WEST SUSSEX COUNTY COUNCIL CONSULTATION

TO:	Arun District Council FAO: Amy Myer
FROM:	WSCC - Highways Authority
DATE:	13 January 2021
LOCATION:	Nursery Fields Land to the North of Chalcraft Lane West Bersted PO21 5TS
SUBJECT:	BE/148/20/OUT Outline application with some matters reserved to provide up to 225 residential units with associated infrastructure, open space and vehicular and pedestrian access. This application affects a Public Right of Way.
DATE OF SITE VISIT:	n/a
RECOMMENDATION:	More Information
S106 CONTRIBUTION TOTAL:	n/a

DRAWING No: ITB14224-GA-009
REV: -

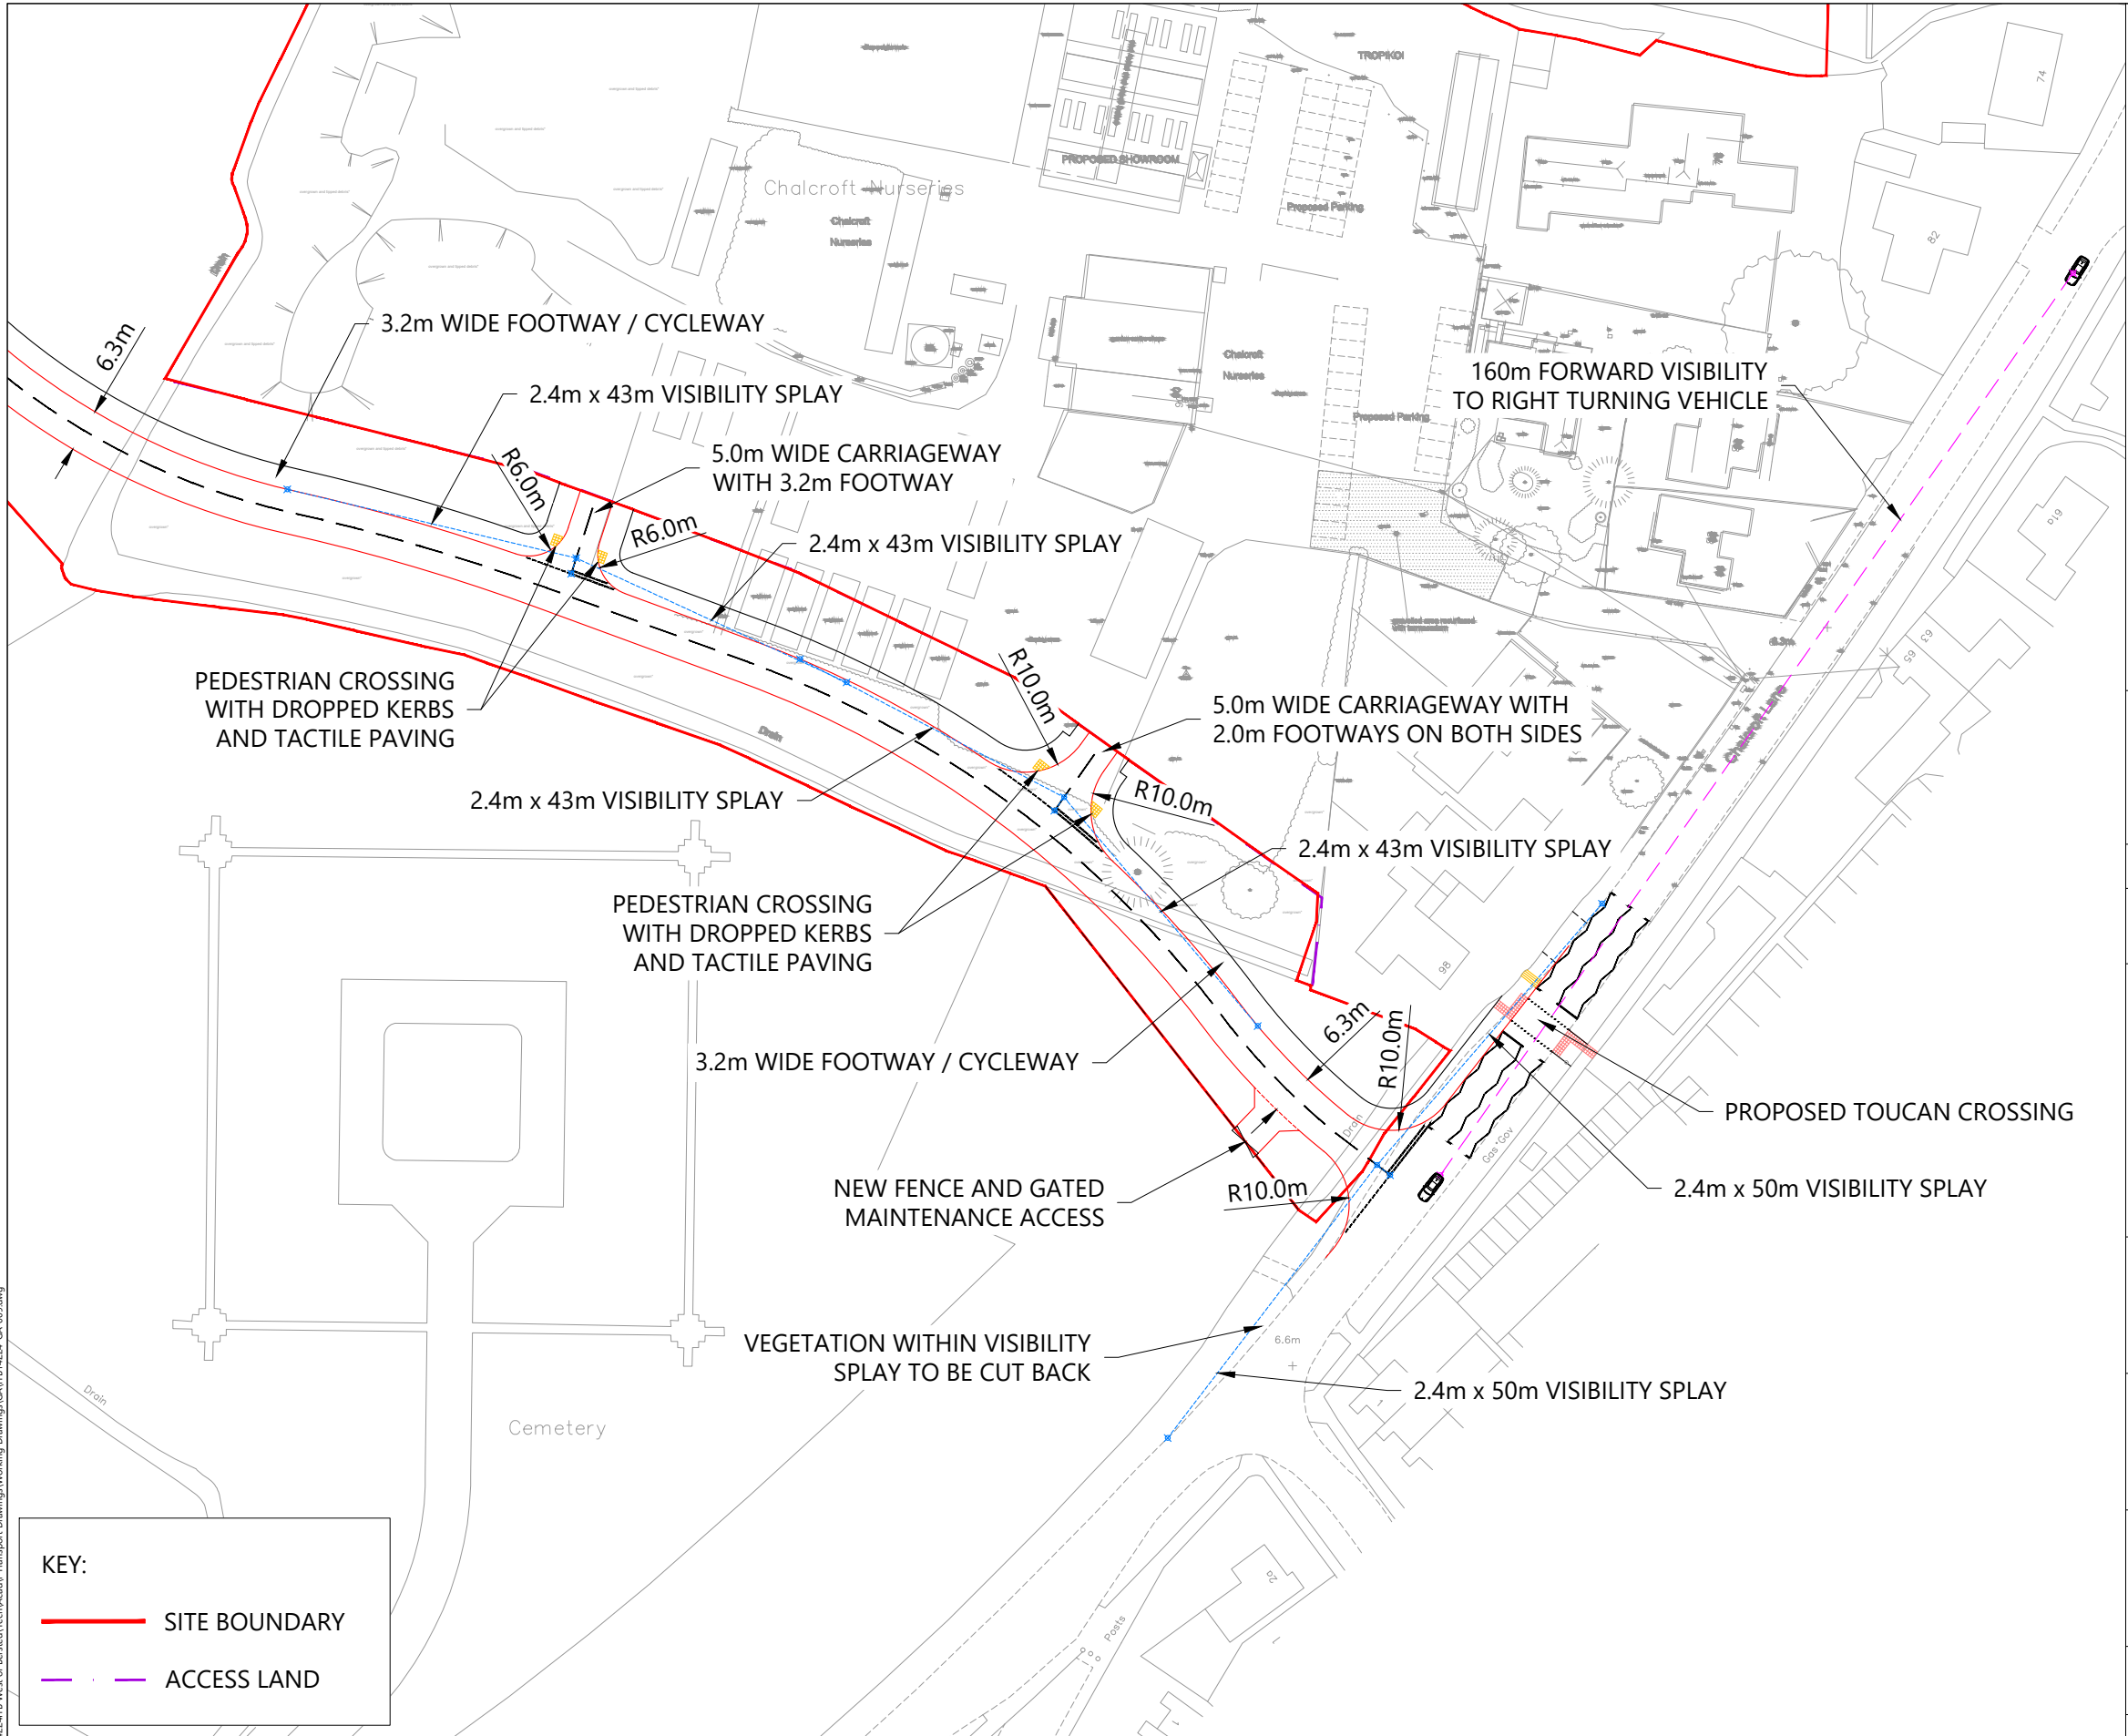
5. Vehicular access is indicated to be via a new priority junction onto Chalcraft Lane. This is shown on drawing number ITB14224-GA-009. This priority junction has already been accepted to serve the development proposed as part of BE/81/20. The current development will understandably add an additional number of vehicle movements through this junction.

6. However given the increase in traffic through the proposed junction, the TA provides further consideration of the suitability of the priority junction to serve the development proposed as part of BE/81/20 and the current application. Whilst the TA refers to highway design standards (namely TA 42/95) that were replaced last year, the capacity assessments provided within the TA indicate that the junction would operate well within theoretical capacity. As such, there are no capacity reasons to seek an alternate form of access.

7. It's understood that the priority junction would have been the subject of a Stage One Road Safety Audit for BE/81/20. The provision of a Stage One RSA is a WSCC policy requirement for all major applications. However it's unclear if the Road Safety Auditor has reviewed the proposed access arrangement on the basis that this would serve both the current application and the development proposed within BE/81/20. Whilst a further new Road Safety Audit is not necessarily required, confirmation is still sought from the applicant that the Safety Auditor has considered the vehicular access on the basis of all development that will now use it.

8. Related to the above point, although the vehicular access remains effectively unchanged, the access drawing now includes a Toucan controlled crossing to the immediate north. Further comments are made on the Toucan crossing and related infrastructure within the 'Access by Sustainable Modes' section.

23. In respects of the current application, a shared foot/cycle way is indicated on the north side of the access road serving the development (it's acknowledged that details of the access road are not to be approved at this stage although such matters are shown on the Green Infrastructure Parameter Plan that is to be approved) linking into a Toucan crossing on Chalcraft Lane. The existing footway on the eastern side of Chalcraft Lane is indicated to be widened to 3.2 metres from the Toucan crossing to Central Drive, from where cyclists will join the carriageway. There is very limited consideration within the TA in terms of how this proposed arrangement complies with current guidance. LTN 1/20 in particular advises against shared use foot/cycle ways and instead promotes the physical segregation of cyclists and pedestrians.

24. Given that the site is indicating pedestrian/cyclist accesses at two other points (namely via footpath 136 (notwithstanding the potential issues identified with this) and onto the community centre access road (which connects to an existing Toucan crossing linking to Central Drive), the provision for cyclists alongside the main access road and the associated works on Chalcraft Lane are potentially superfluous and as shown conflict with LTN 1/20.

25. It's recommended that this aspect (namely the provision of shared use facility within the development, the Toucan crossing, and the proposed widening works along Chalcraft Lane) of the application is either removed or reassessed and amended to ensure compliance with LTN 1/20. In the event this southern route is removed, the Green Infrastructure Parameter Plan would need to be updated.
